Our ref: WA/2021/129266/02-L01
Your ref: 21/02286/F
Date: 09 December 2021

Construction of a coffee unit with drive-thru facility and indoor seating with associated access, car parking, landscaping and servicing parking

Land north west of Launton Road roundabout adjoining Skimmingdish Lane, Caversfield

Title FLOOD VOLUMES SECTIONS 2 OF 3 Original drawing sheet is A1

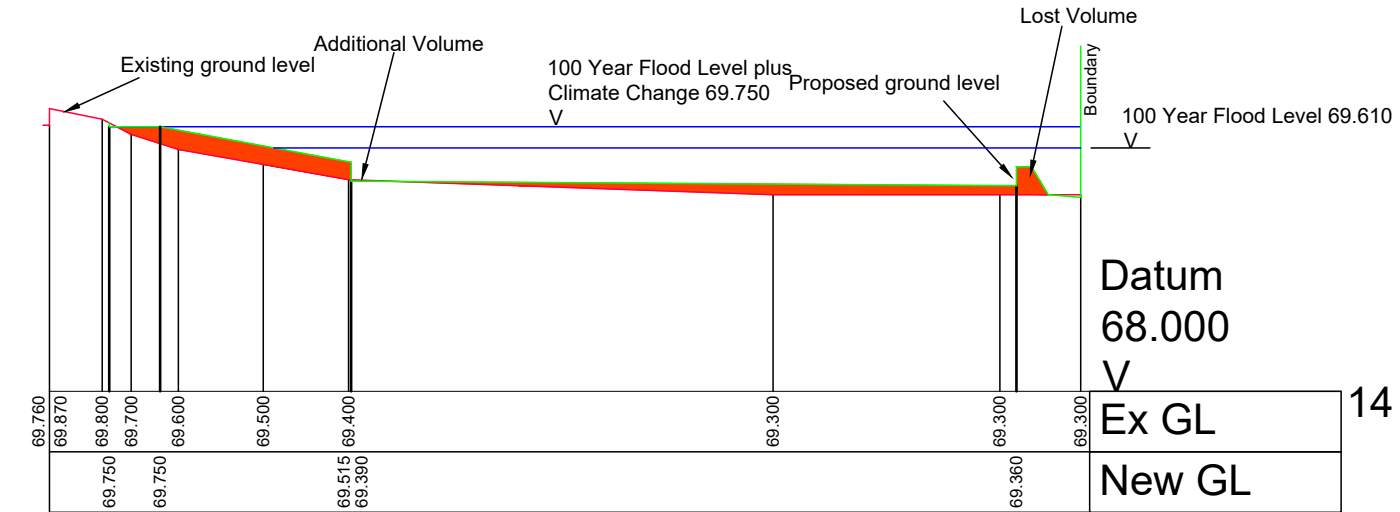
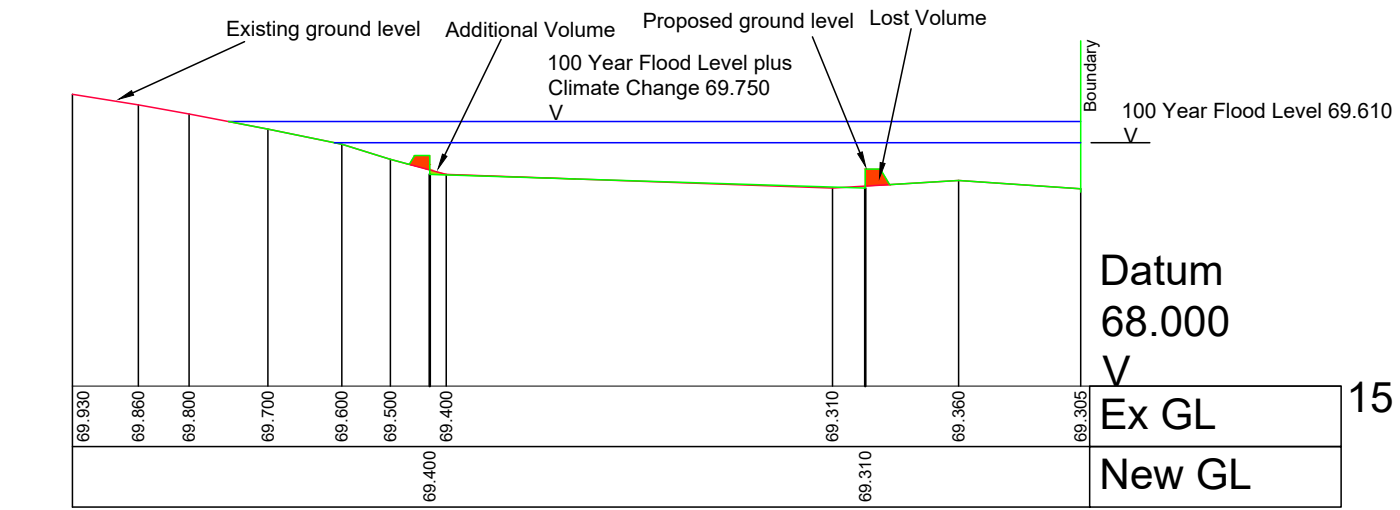
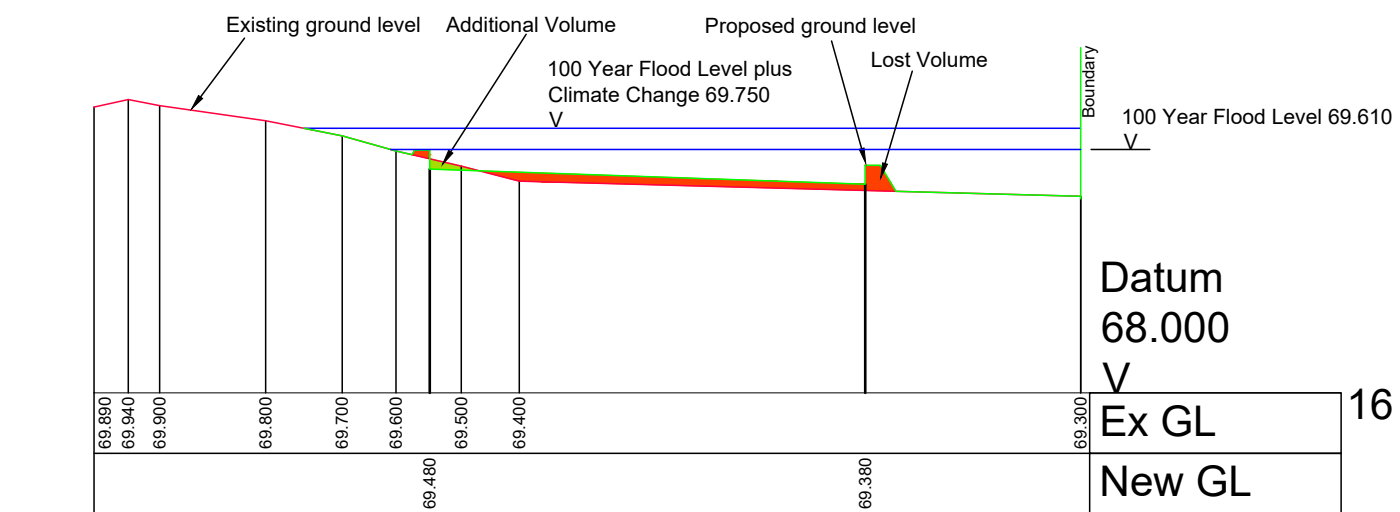
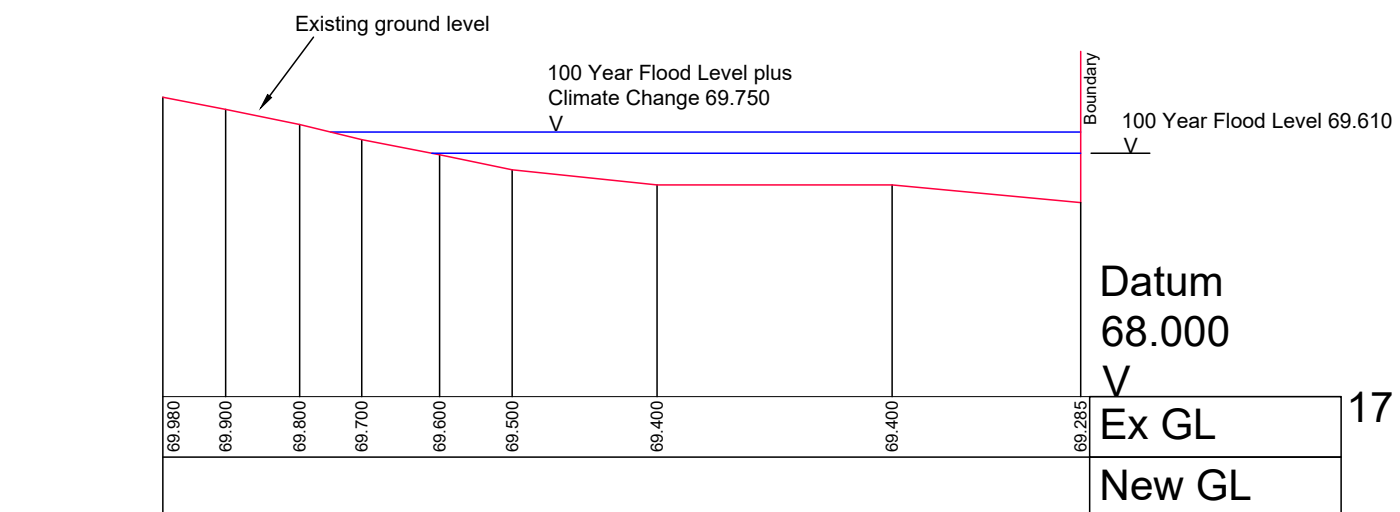
These revised details have reduced the underground storage tank requirement to 36.5m³. While this is less than previously proposed, it is still substantially more than we agreed with the applicant during pre-application discussions and we are not satisfied that this method in this volume is acceptable.

In addition, we note that the excavation required to provide the proposed floodplain compensation area is detailed only on cross sections. Without a plan it is hard to establish whether the information shown on the sections is practical and achievable. It will be necessary for the applicant to submit a plan showing the floodplain compensation storage area and detail the ground levels required for the area, consistent with the sections.

During pre-application discussion with the applicant, it was agreed that flood storage for the tank system would equate to 30m³. While the tanked storage now required is significantly less than previously proposed, a system of 36.5m³ is a 20% increase over the agreed proposal. We consider this to be inappropriate for this level of compensation. We have previously advised on the use of open voids within the design of the building as a possible solution, however the applicant has discounted this due to other constraints. Therefore, additional land suitable for level for level flood storage should be sought or the development revised to reduce the amount of flood storage being lost.
